Office of
Environment
& Heritage

Your reference: 10/11837
Our reference: FIL07/13603 DOC11/29762
Date: 27 June 2011

Exhibition of Environmental Assessment for Epuron, White Rock Wind Farm (Application Reference MP 10_0160)

ATTACHMENT 1 – OEH SUBMISSION FOR PROPOSED EPURON WHITE ROCK WIND FARM KEY ISSUES AND COMMENTS ON DRAFT STATEMENT OF COMMITMENTS

Figure 9-12 Potential offset locations

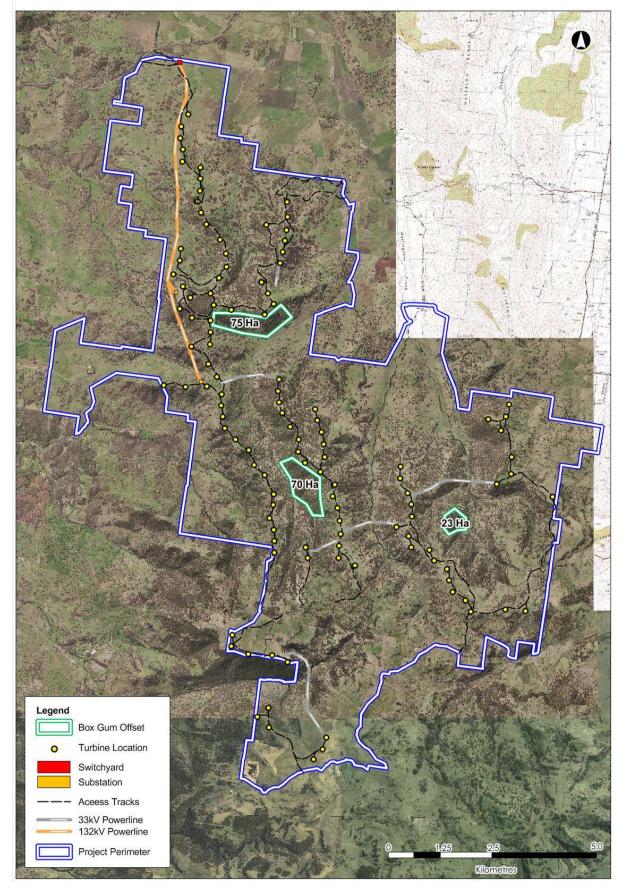
- a) Other than identifying three potential areas for conservation and indicate that the proposed offset will be "*at least 44ha in total*", the proponent has not proposed any specific offset areas.
- b) The proponent has made no attempt to assess the proposed offset areas against the Department's '*Principles for the use of biodiversity offsets in NSW*'. Indeed, the proponent is uncertain as to whether the required vegetation type occurs within the proposed offset areas.
- c) The EA presents no detail regarding the condition of the impact and offset sites. Such data is essential to calculate the offset required for the loss.

- d) OEH considers that the offset area proposed may fall short of that required to adequately offset the impacts of the wind farm. The exhibited documents, while identifying potential offset areas, do not contain sufficient information to allow any assessment of the offset areas. To suggest that the proposed offset will be “at least 44ha in total” does not take into account assessment of condition of either the impact or offset areas.

- f) Should areas of Derived Native Grassland be identified this will need to be quantified to enable calculation of adequate offsets.
- g) While it is stated that the offsets are not considered too close to the wind farm, two of the three identified offset areas appear either in close proximity to turbines or where turbines could well impact of the ability of fauna to access the site once site conditions are improved.

- a) Considers the conservation value of the vegetation to be impacted;
- b) Adequately assesses the condition of both the impact and proposed offset sites;
- c) Proposes an adequate offset, the quantum of which is justified by a suitable metric or other scientific methodology, and which also meets the Department’s *Principles for the use of biodiversity offsets in NSW*; and
- d) Includes a proper description of the proposed offset, including maps.
